Please ask for: Ms Iqraa Malik
Email: iqraa.malik@terraquest.co.uk
Telephone: 01212341390
Our Ref: K/16/21/HH
Your Ref:
Date: 23rd April 2021

Application for Planning Permission for Works or Extension to a Dwelling

Development: Internal alterations to existing dwelling. Demolition and replacement of existing rear extension with new single storey extension and first floor terrace above with external staircase. Replacement of main roof and 4no. new dormers with windows. Replacement roof tiles to single-storey projections on North elevation. Proposed rear single storey minor extension to garage to form entrance lobby. Alterations to external facade of house and replacement windows and doors throughout. Associated landscaping to suit.

Location: Sea Lodge 7 Coastal Road Kingston BN16 1SJ

Site Block Plan
1:200 @A3

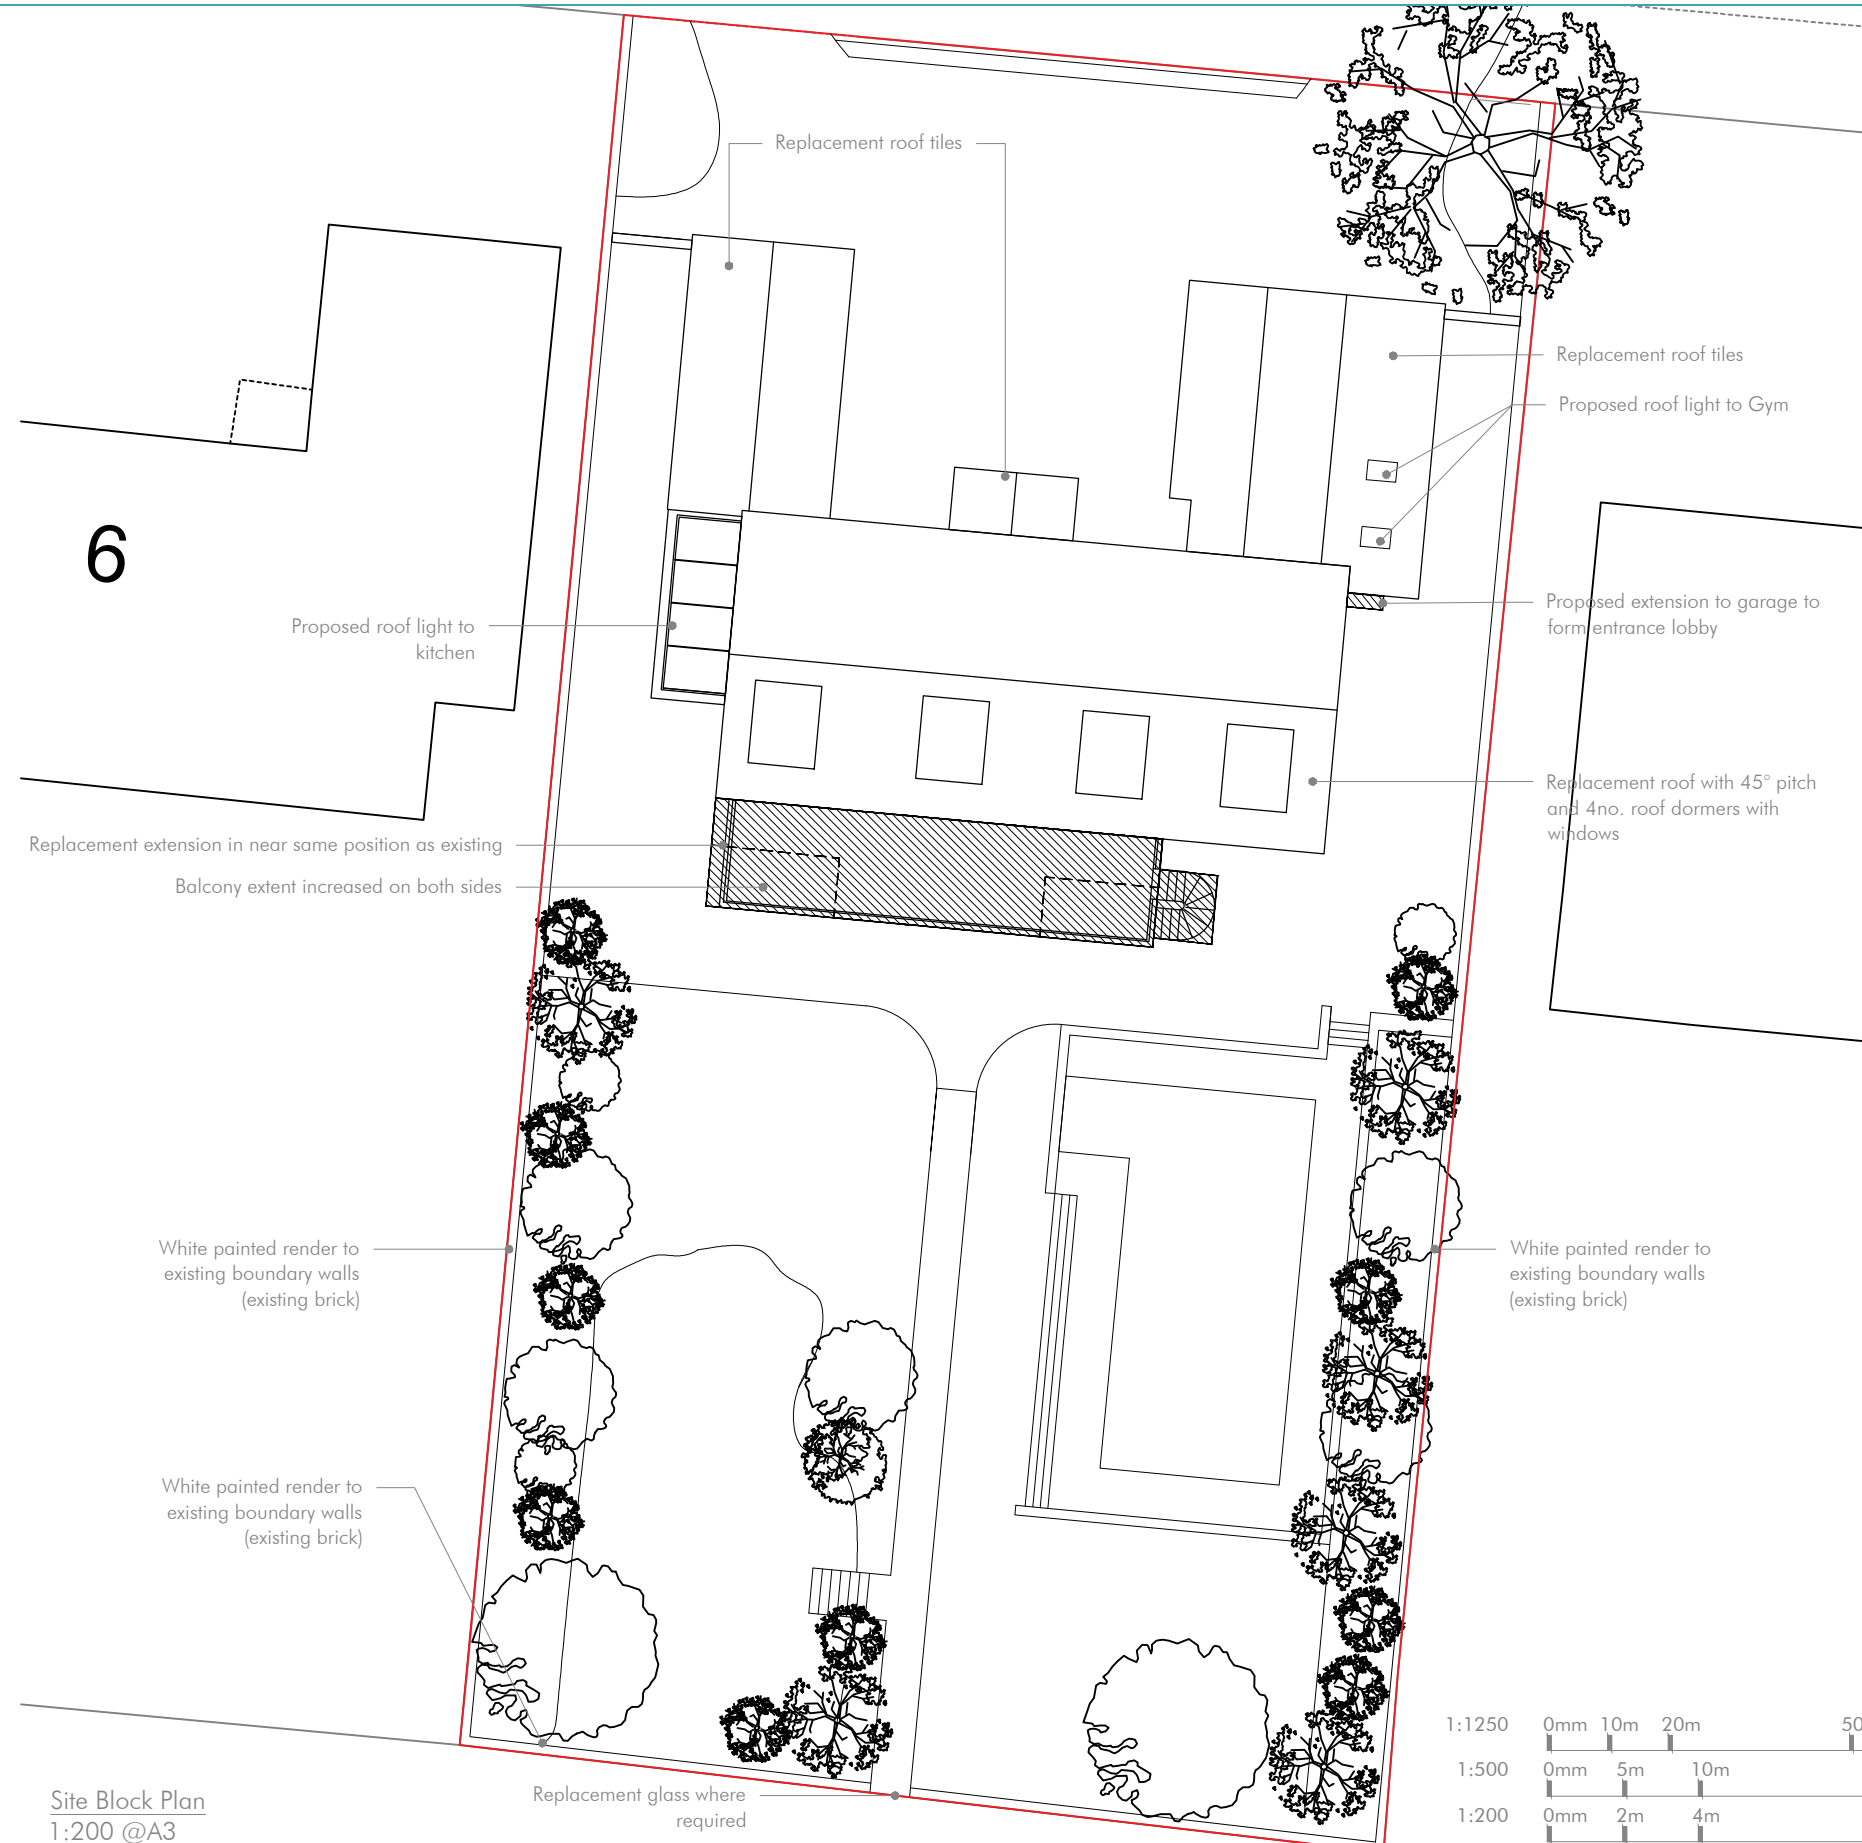
Block Plan

You are required to have dimensions from the proposed extension(s) to all site boundaries. Please amend.
